**From:**  
**To:** [DCAdmin](#)  
**Subject:** 2020/62/93954  
**Date:** 03 December 2022 19:33:37

It appears that the windows of the lounge in flats 15/ 16 are not the required distance of 21 metres from my property no 45 Lingards road.

Plot 15
50 m² (538ft²)
1 bed, 2 person flat.

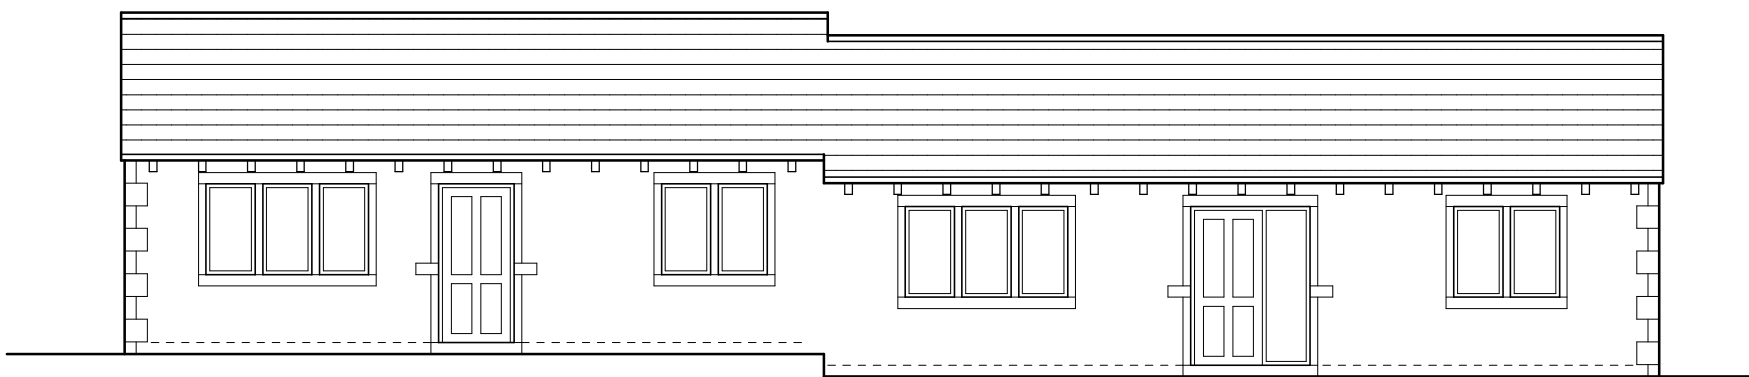
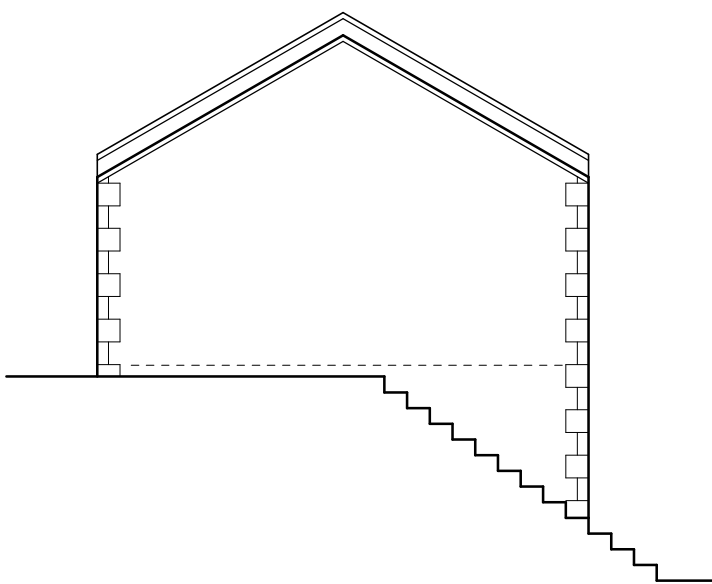
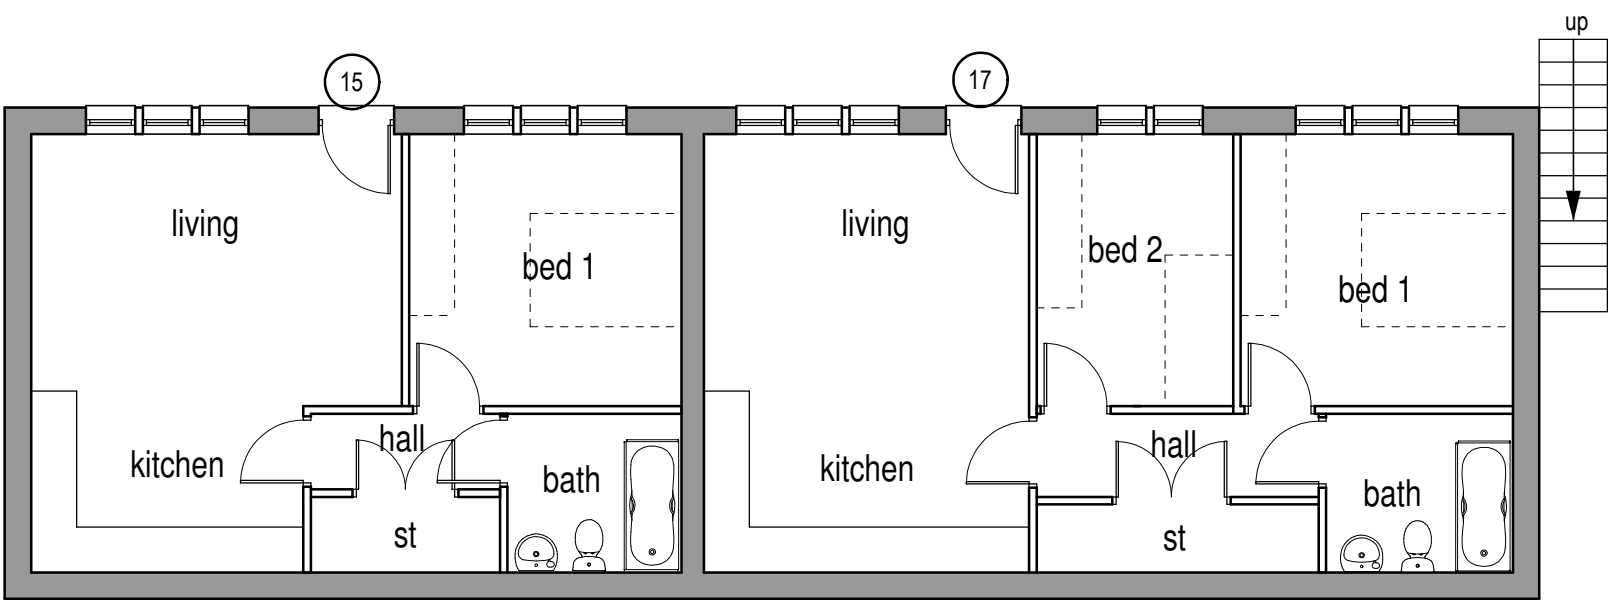
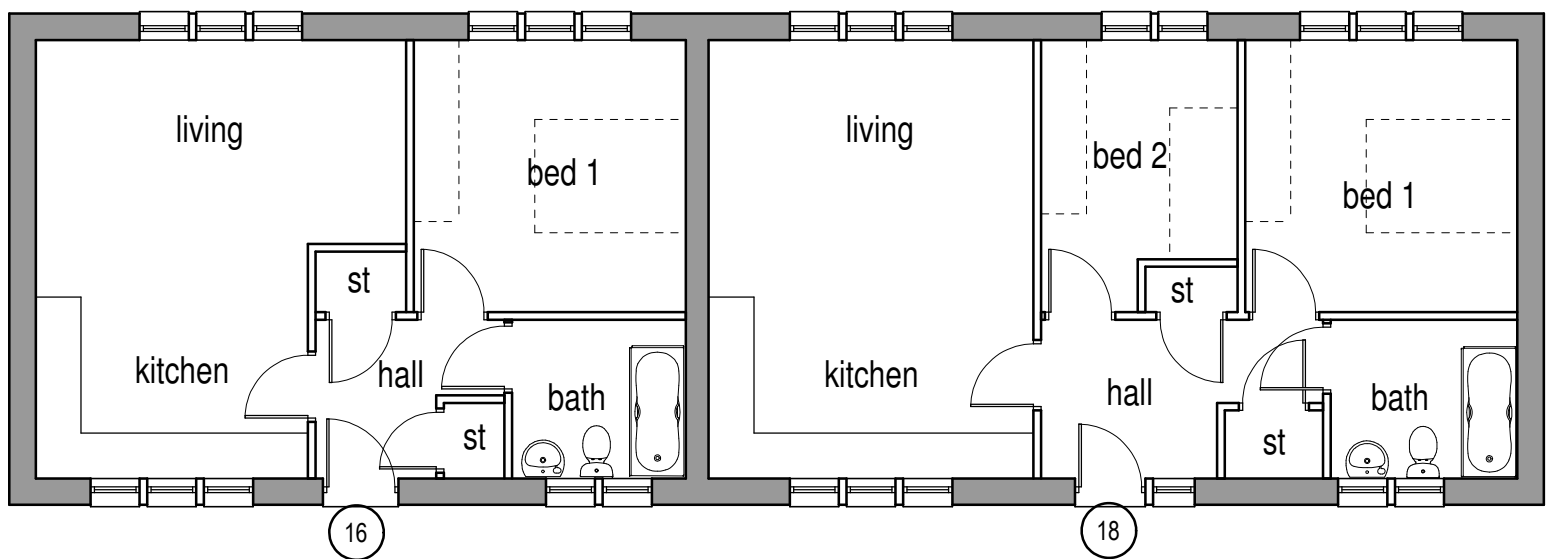
The plans differ with disingenuous measurements from my fence to the gable end of the flats 15/16 designed to imply that the road distance and level will have no impact on my house and outdoor leisure area.
